Recommendation Report for Planning Permission for Works or Extension to a Dwelling

REF NO: WA/57/20/HH

LOCATION: 8 Prime Close
Walberton
BN18 0PL

PROPOSAL: Extension to roof and loft conversion

Project : Roof Extension  
Title : Elevations  
Drawing N.O : PL CC 0101 / 2020

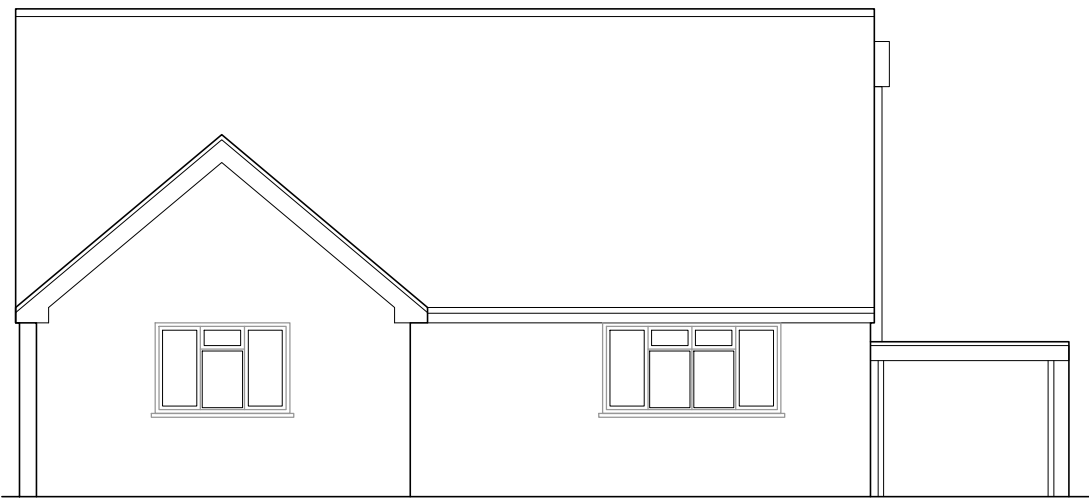
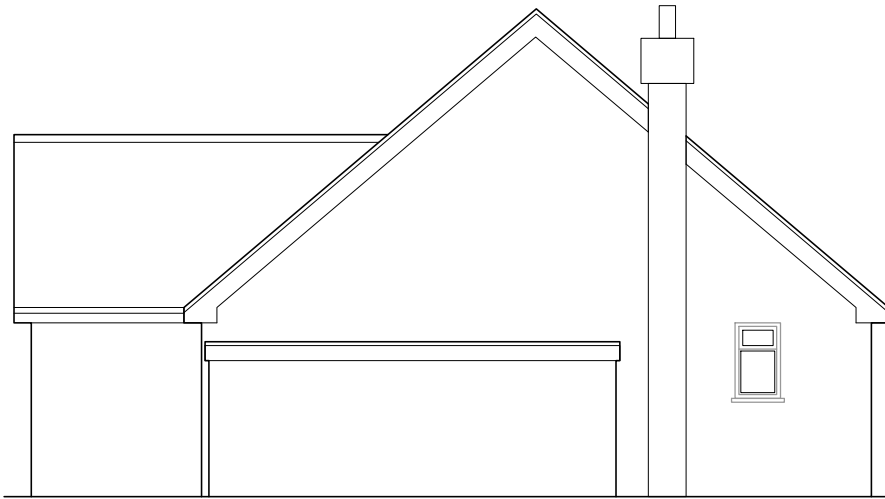
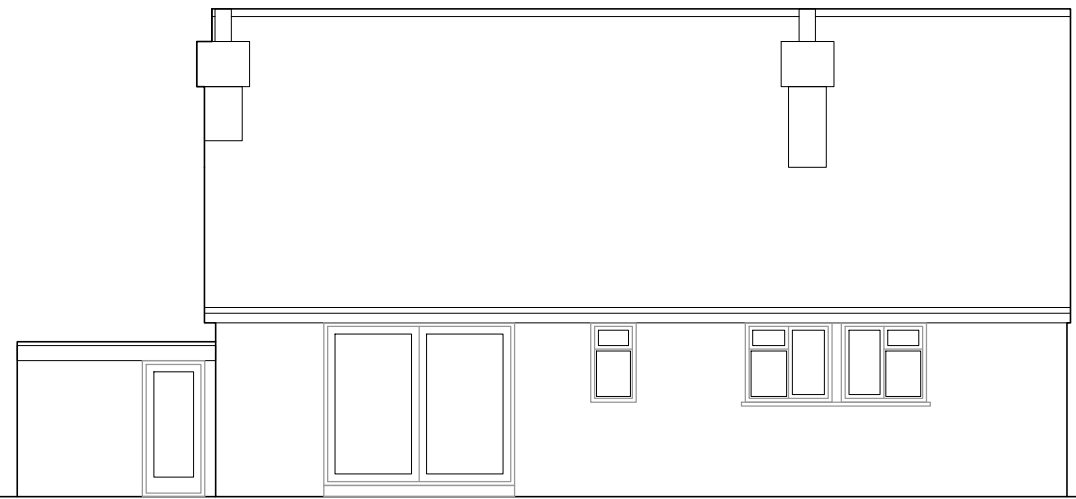
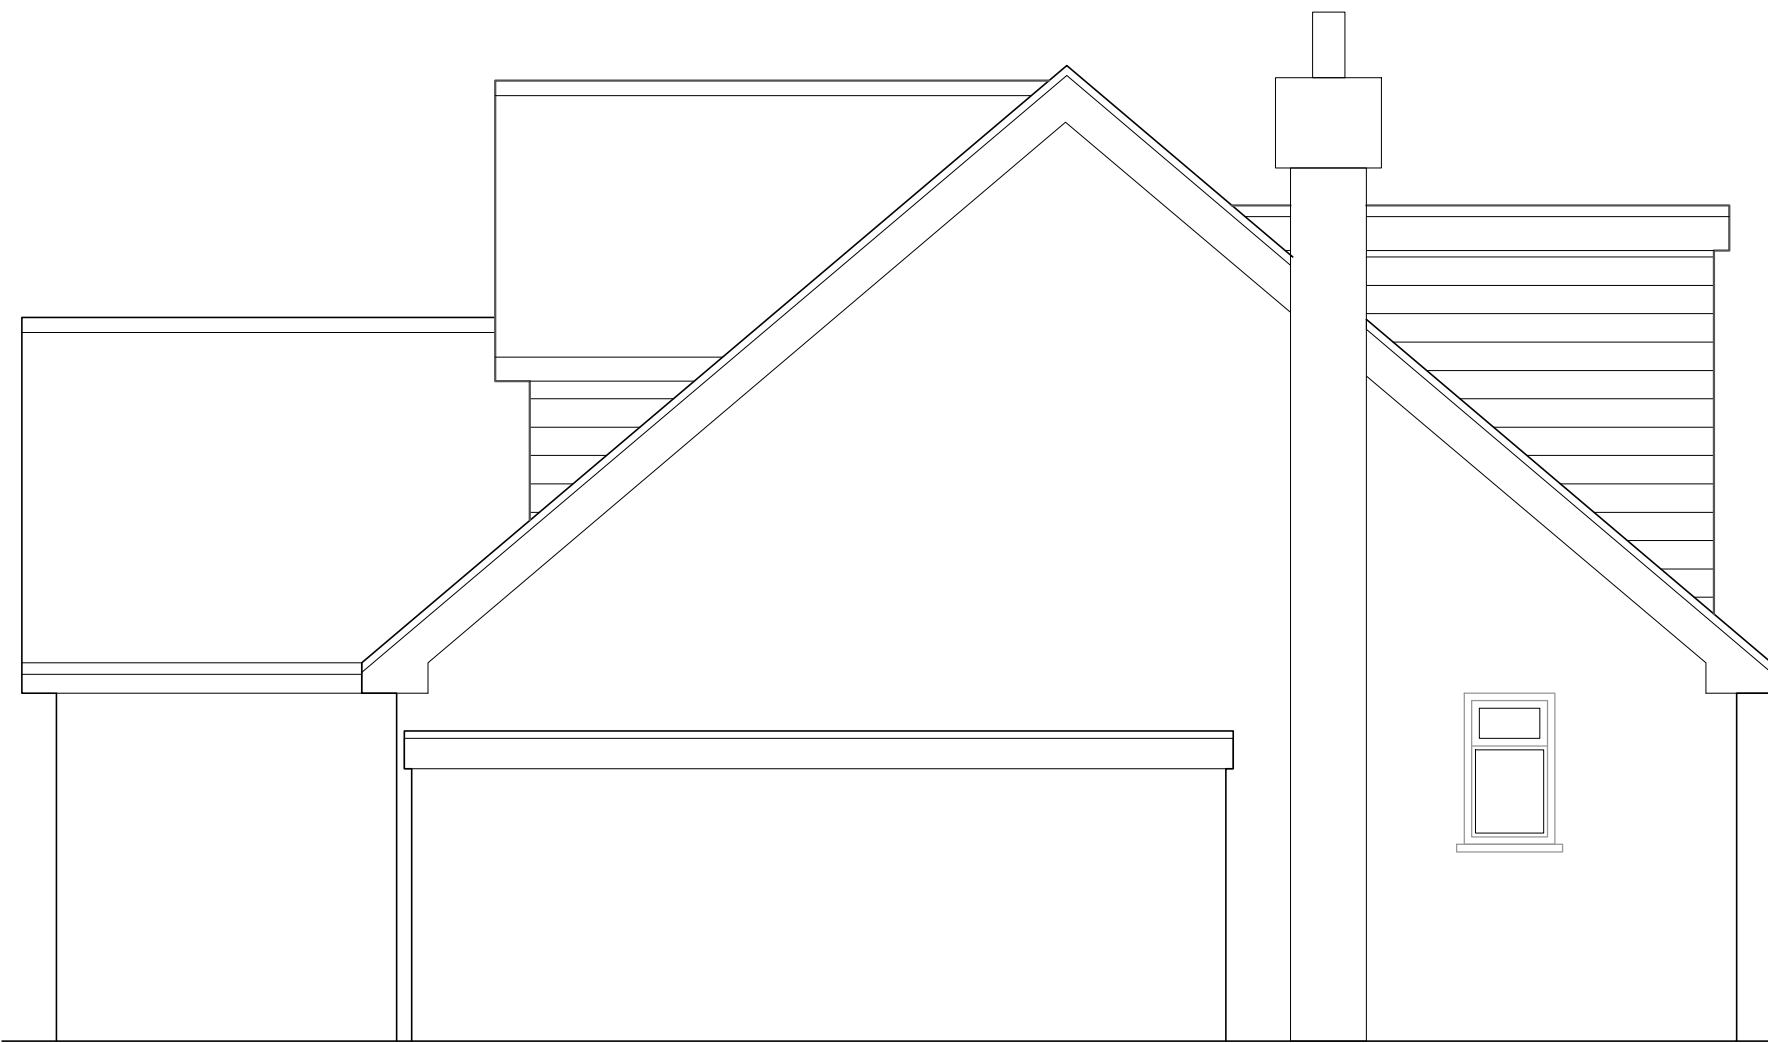
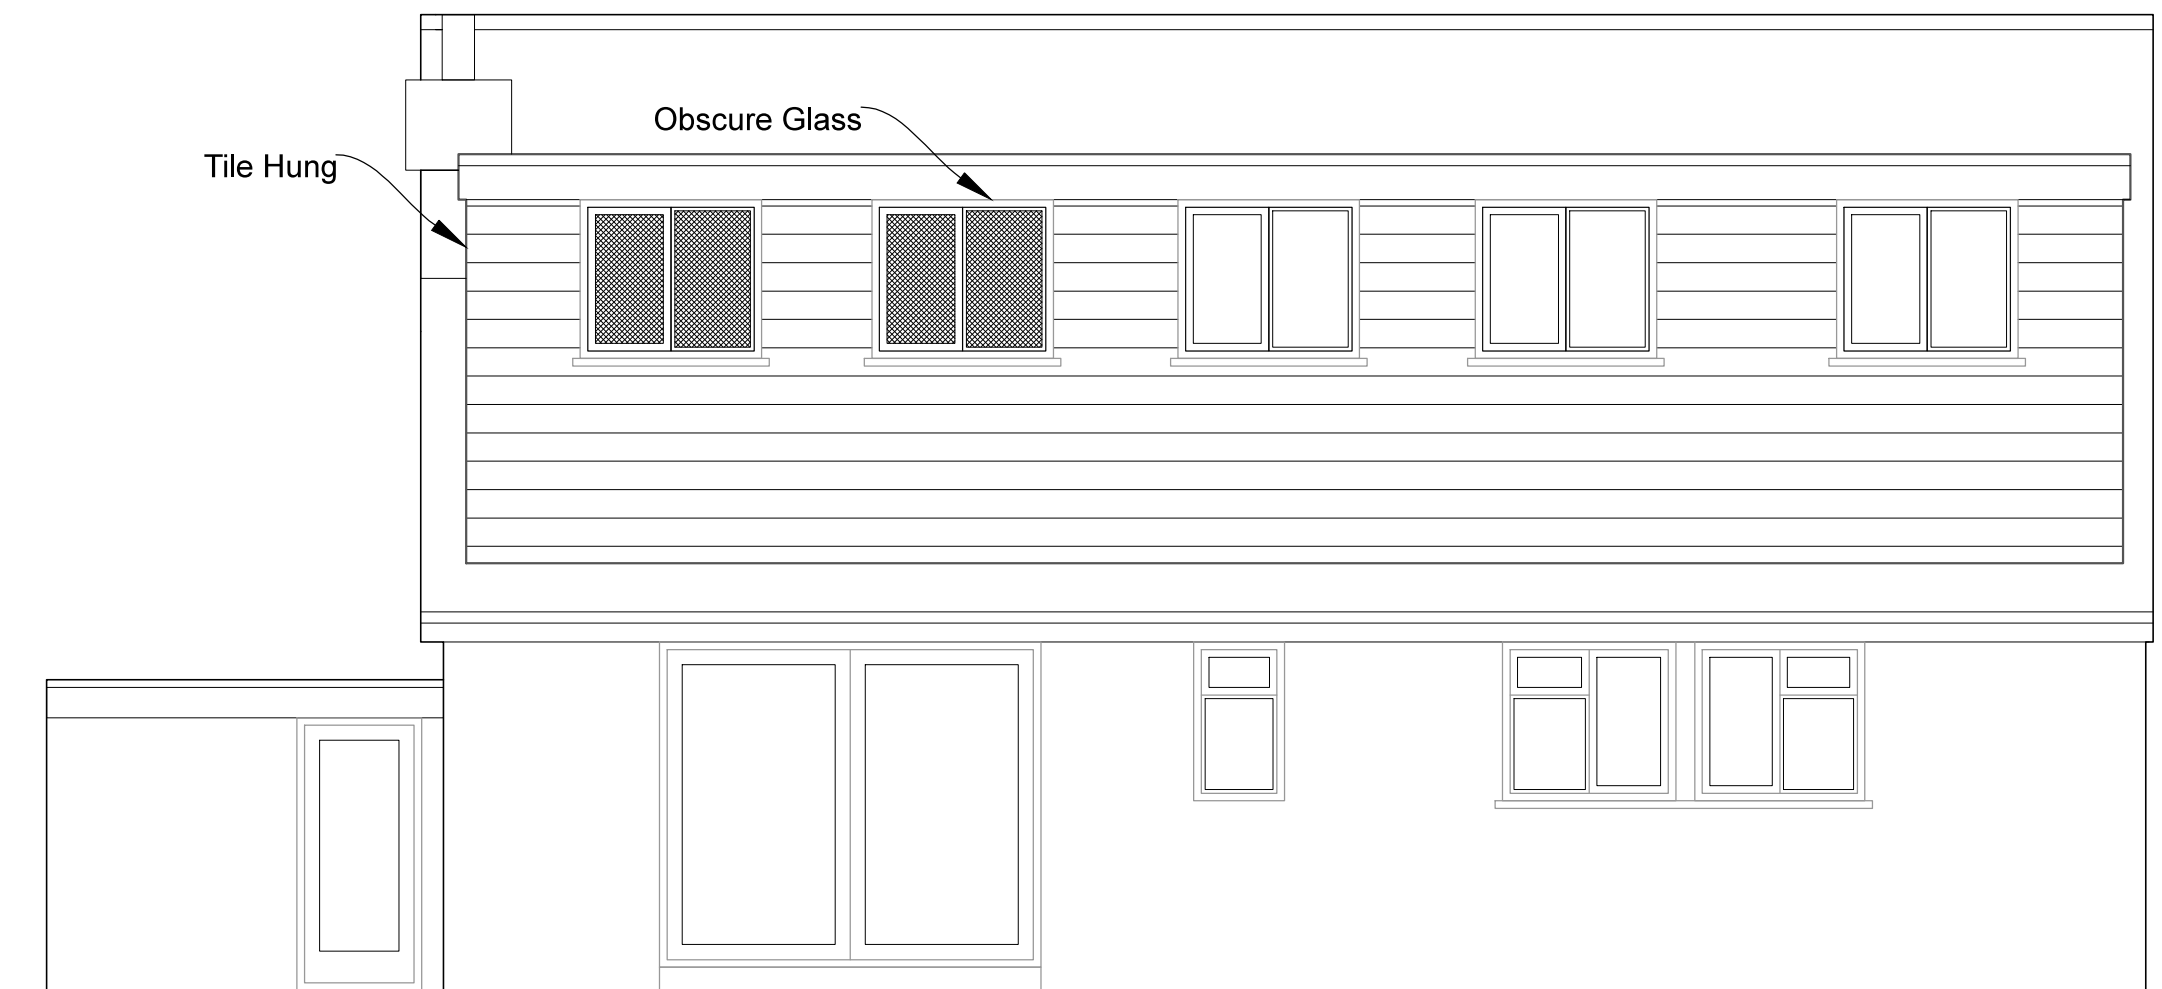
DESCRIPTION OF APPLICATION The application seeks to convert the roof space to habitable space, by way of the construction of a rear dormer extension, and the insertion of rooflights. Initially the application proposed a front dormer, however, this was changed to front Velux windows following negotiation.

- The proposed front dormer window is out of character with the bungalows in the area.
- There are no examples of front dormers in the area.

Comments noted. It is noted that the objection comments predominantly relate to the front dormer, which has been removed from the proposal.
